**Albuquerque  
Metropolitan  
Arroyo  
Flood  
Control  
Authority**

March 21, 2012

Re: Drainage Management and Construction Plans for APS Community Stadium  
Engineer's Seal Dated 3-12-12

I have reviewed your response letter, dated March 7, 2012, and the revised plans and have the following additional comments:

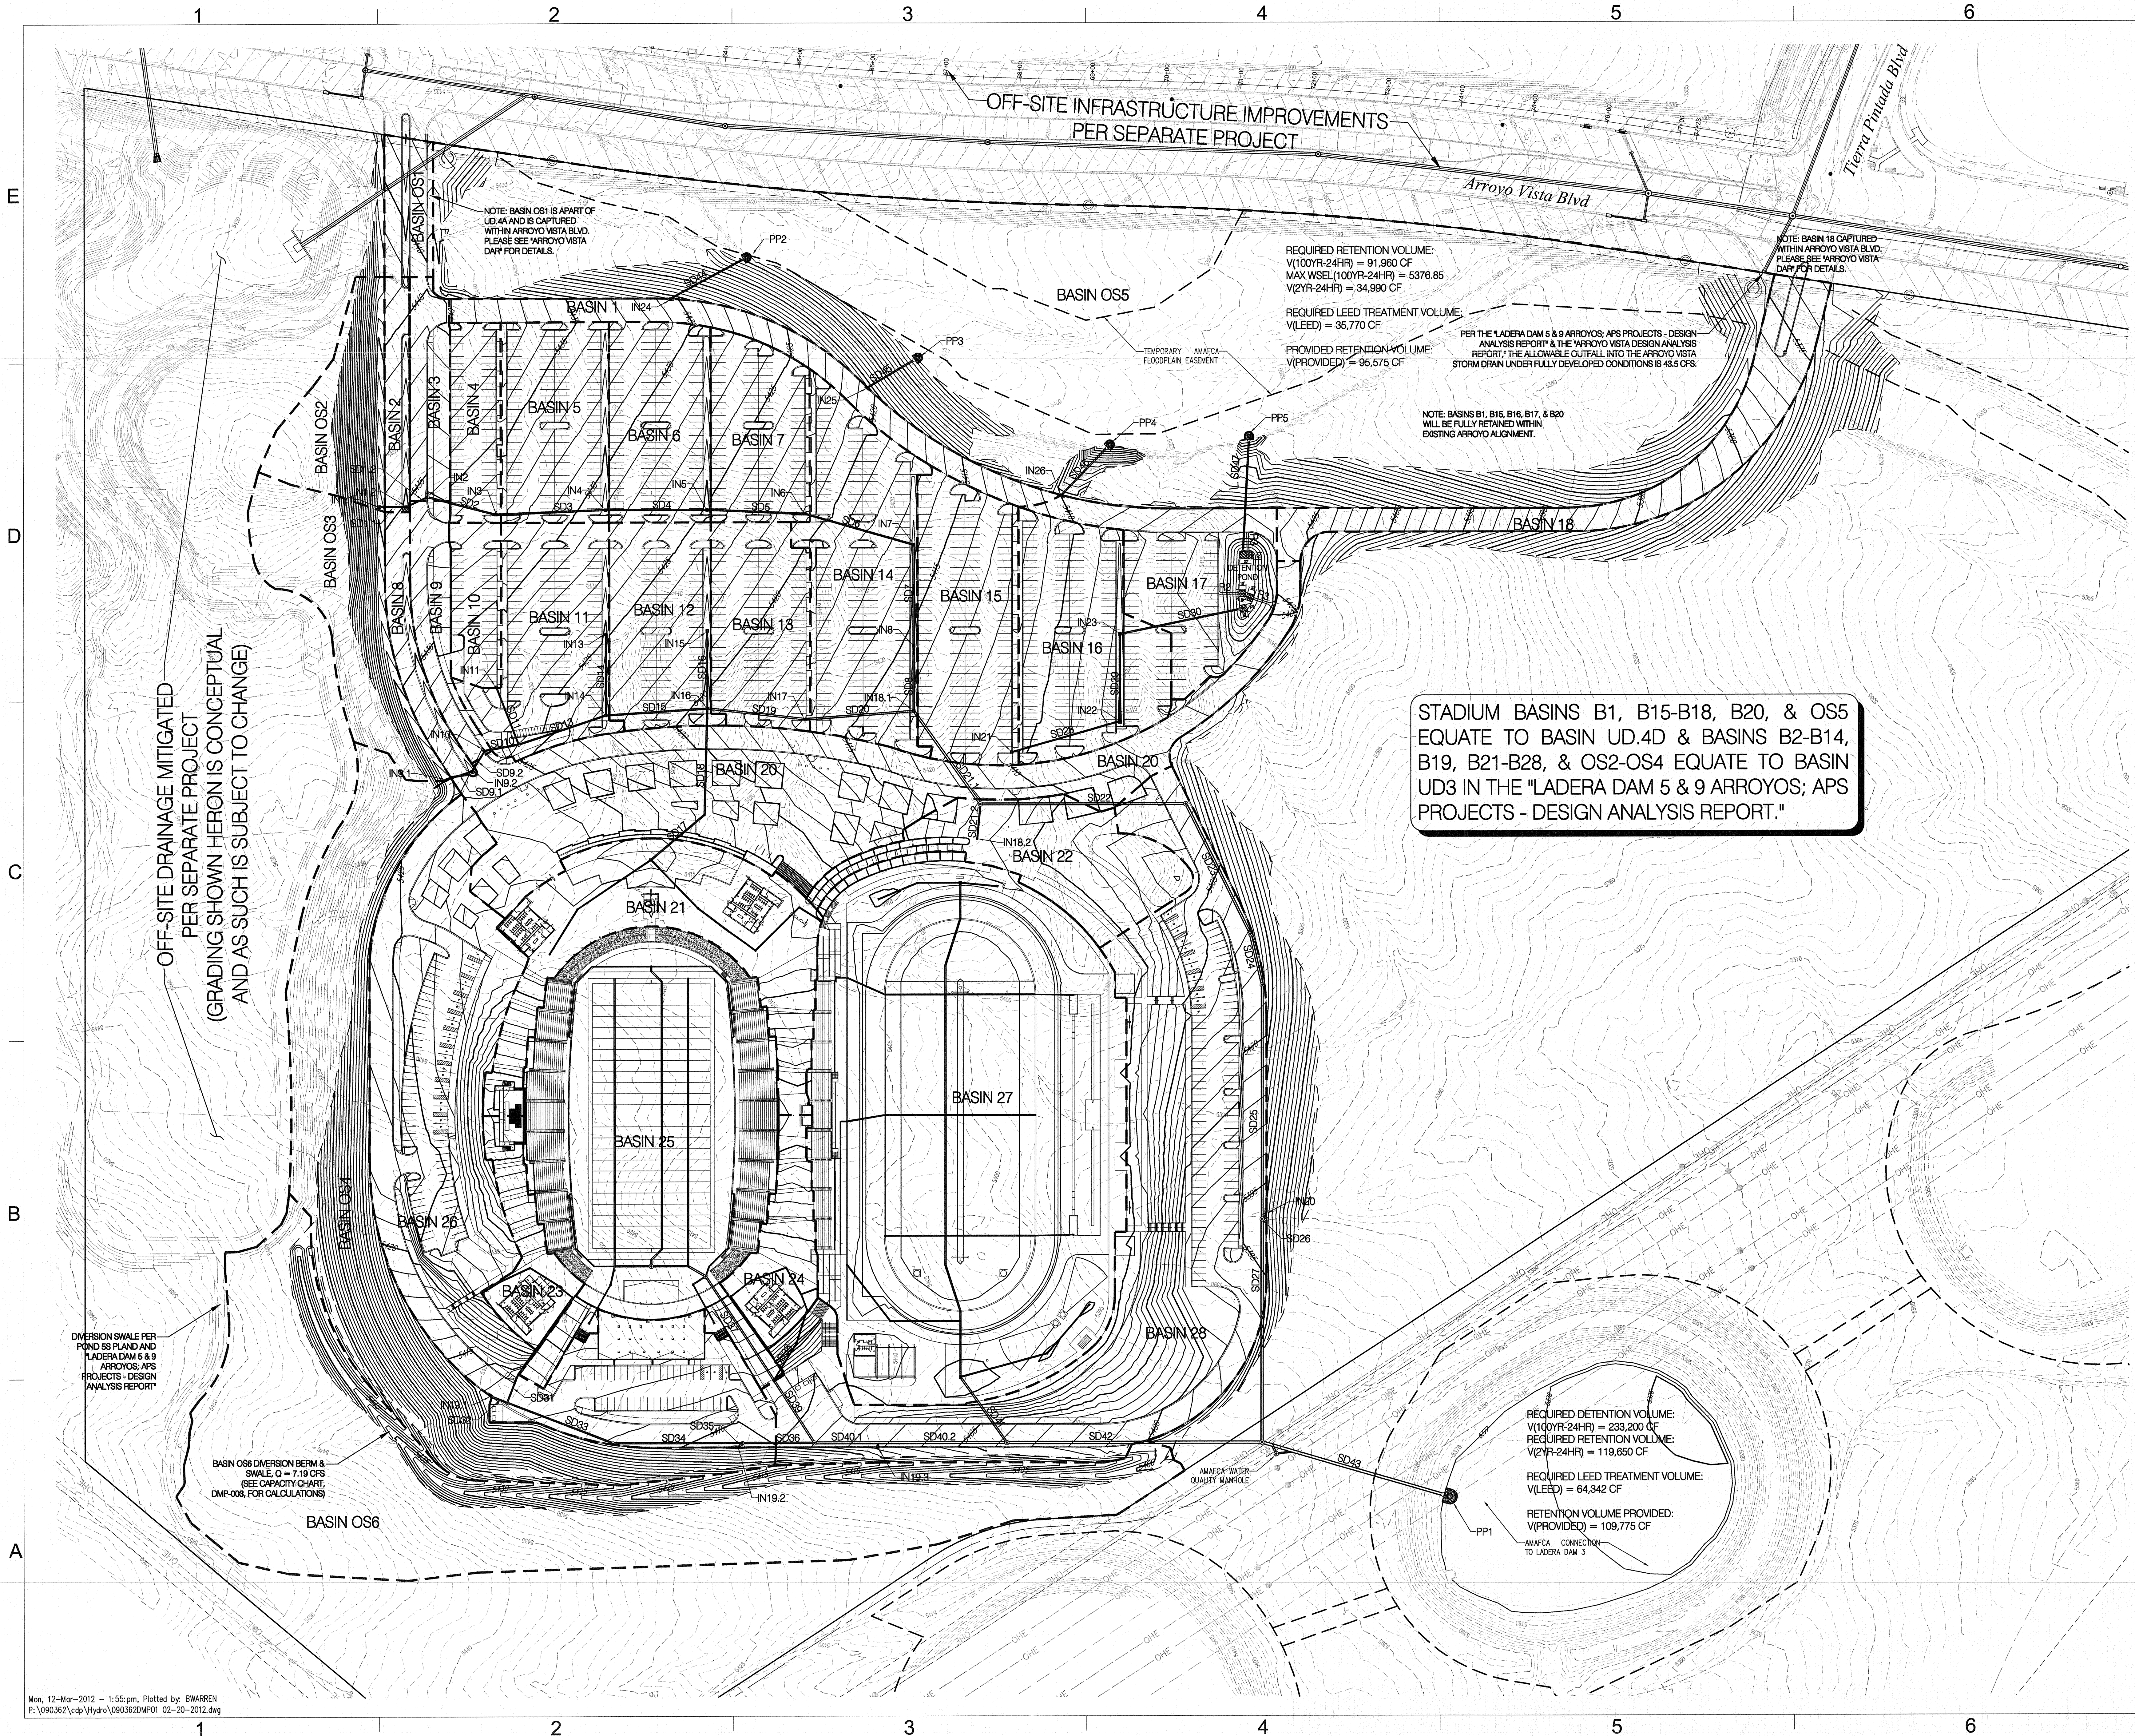
1. On Sheet DMP-002, change the reference to DAR Basin UD.4D to UD.4A.
2. Your response to the impact on the storage volume of Ladera Dam 3 from additional drainage area is noted; however, I would like to see additional clarification. Was the storm drain system analyzed in an AHYMO model? If so, provide a comparison of the volume of flow from SD-43 outfall to the flow volume from DAR Basin UD.3. If not, estimate the volume of flow in SD-43 for comparison.
